From: Nicola Fry [REDACTED] **On Behalf Of** CCD Planning Consultations
Sent: 06 April 2018 13:29
To: Planning.Responses
Cc: Deborah Urquhart
Subject: **Warning Active Content** RE: Planning Consultation on: A/31/18/OUT

APPLICATION **A/31/18/OUT**
NO:

Site Address: Land to the North of 68 Arundel Road Angmering BN16 4LL

WEST SUSSEX COUNTY COUNCIL CONSULTATION

TITLE:
GROUND FLOOR
PLAN

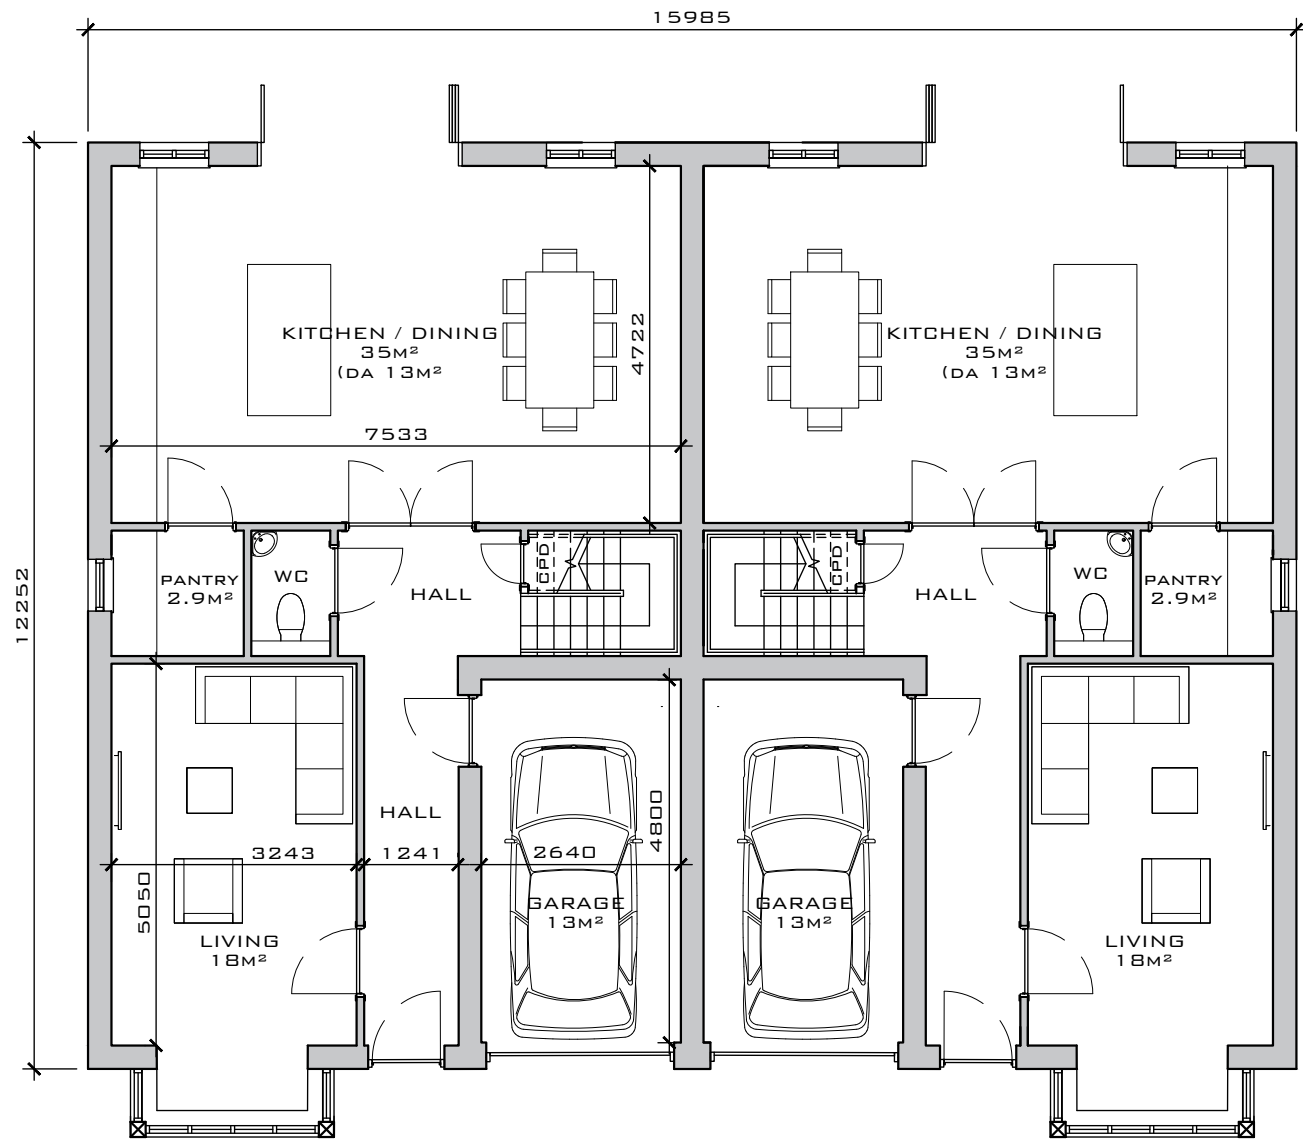
The proposed outline plans detail that each dwelling will contain one integral garage and additional parking to the front of the property, although further details have not been determined at this stage. The WSCC parking demand calculator expects that a minimum of two car parking spaces will be required per dwelling for a development of this size and location. The LHA advises that in order for the integral garages to be counted as allocated parking provision, the internal dimensions of each garage must meet minimum dimensions of 3x6m as set out in MfS. We expect that this would be demonstrated at Reserved Matters stage. Each external parking space should be a minimum of 2.4x4.8m. A turn on site has not been demonstrated but appears achievable in this location.

TITLE:
SITE BLOCK PLAN

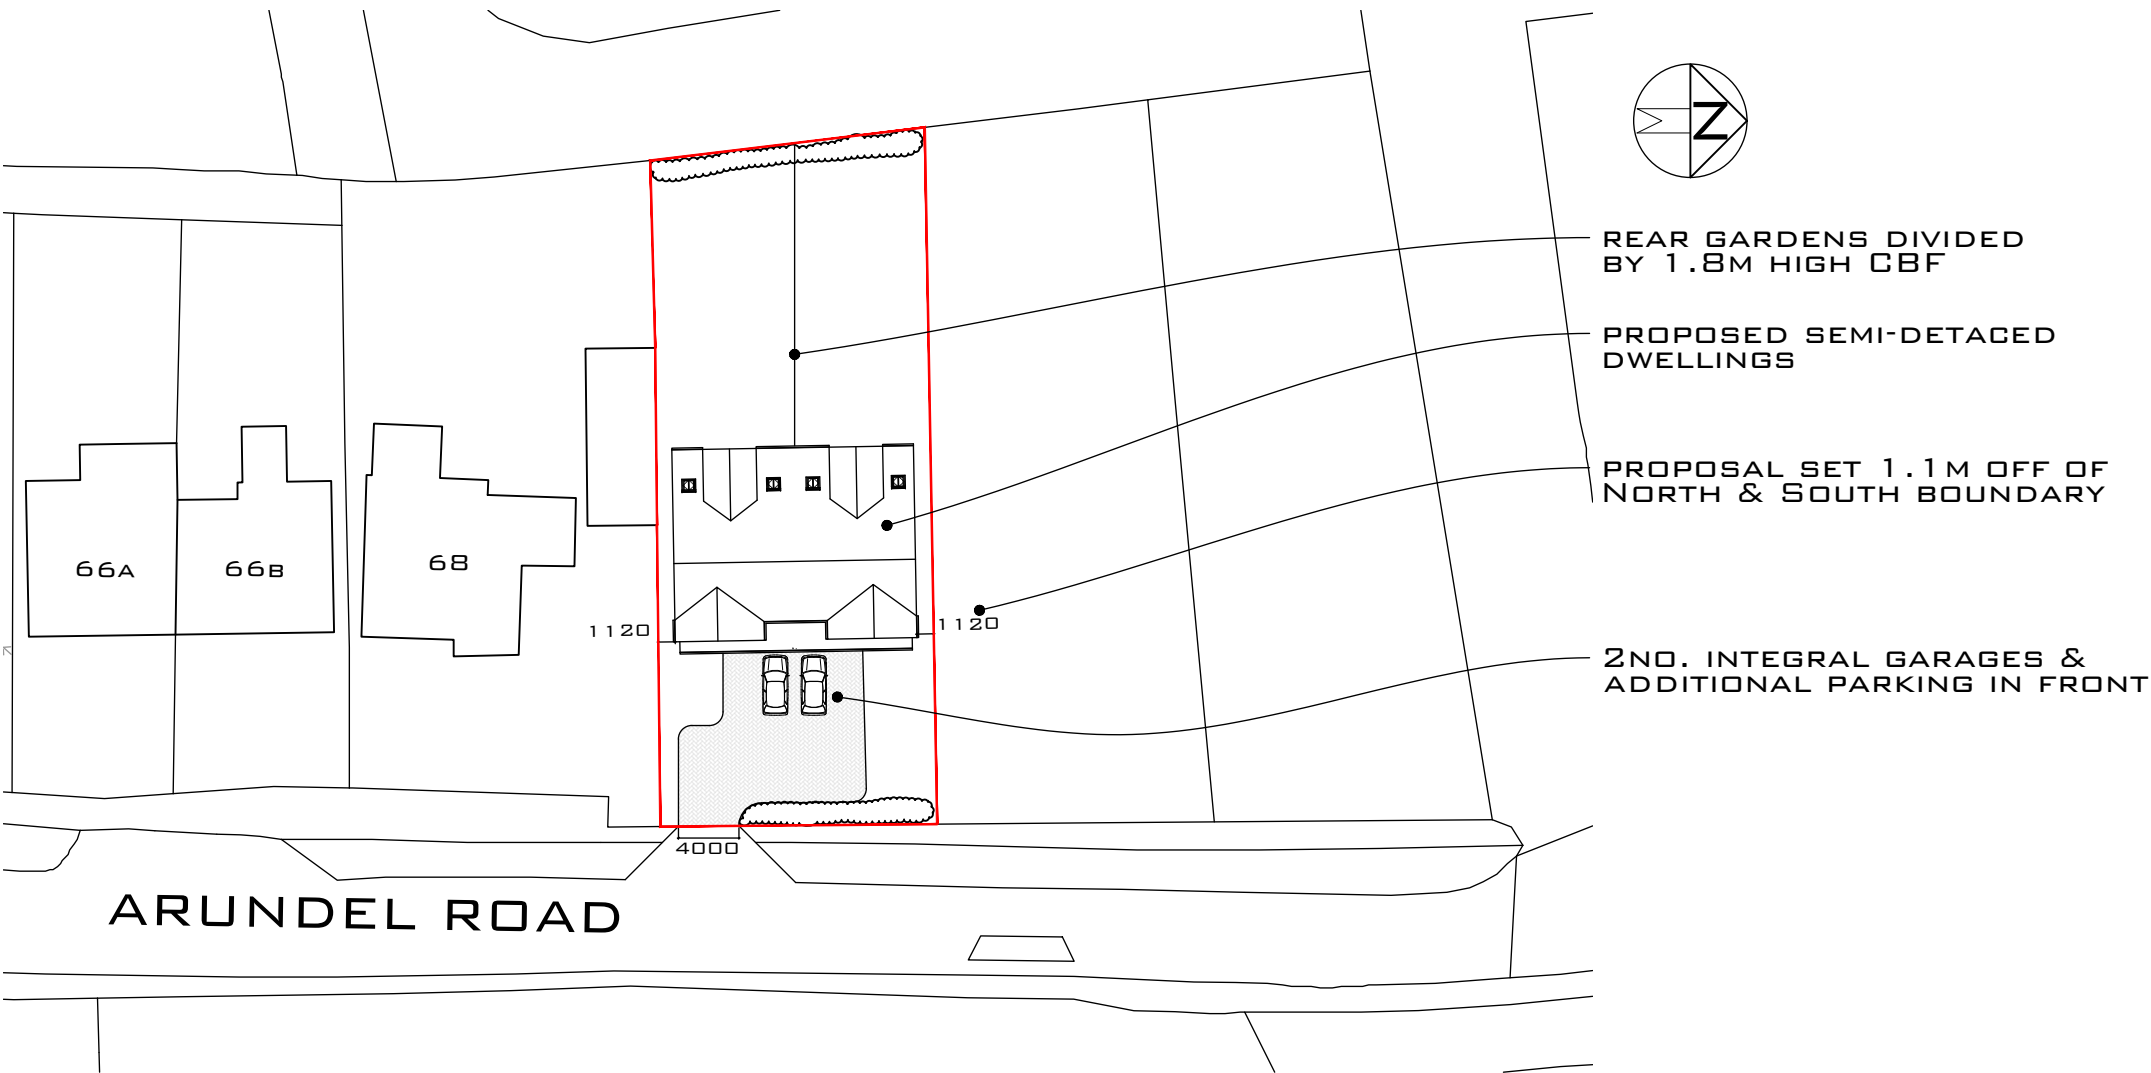
A new 4m wide shared access is proposed onto Arundel Road which should be constructed to a specification agreed with the Local Highways Engineer. Considering the access is to be shared between two dwellings the Local Highway Authority (LHA) advises this be widened to 4.5m to allow two cars to pass within the access.

The driveway material has not been determined within proposed plans; the LHA require that the driveway be constructed from a hardbound material, or gravel traps provided to prevent spillage onto the highway.

Pedestrian visibility has not been demonstrated. Whilst the LHA appreciate there is a 1m wide strip of overgrown highway verge there would be benefit to increasing pedestrian visibility splay back into the site, either side of the proposed access. This would require that the proposed access be relocated slightly north. Considering that the LHA have advised that the access is widened we would anticipate that details of the amended access including vehicle and pedestrian splays can be secured at reserved matters stage. Pedestrian visibility splays should be taken 2m back into the access and

a distance measured along the back of the footway for 2m on each side of the access. Boundary treatments should be maintained to a maximum height of 0.6m within these splays.

Vehicular visibility at the proposed access has not been demonstrated by the applicant, however, an inspection of local and WSCC mapping indicates that visibility at this location is sufficient for the posted limit. An inspection of local mapping reveals that 2.4m by 43m is achievable entirely within the publically maintained highway, in line with guidance set out in Manual for Streets (MfS). It would appear that hedgerow within the public highway would require cutting back to maintain these splays. The LHA would advise that splays are demonstrated at reserved matters stage. An inspection of data supplied to WSCC by Sussex Police over a period of the last five years shows that there have been no recorded injury accidents within the vicinity of the proposed site. As such, there is no evidence to suggest that the addition of two dwellings will give rise to a capacity concern or would exacerbate an existing safety concern.

The LHA does not consider that the principle of the proposal for two dwellings would have 'severe' impact on the operation of the Highway network, therefore is not contrary to the National Planning Policy Framework (paragraph 32), and that there are no transport grounds to resist the proposal. We would however require that details of the amended access, visibility splays, parking and turning are provided at reserved matters stage.
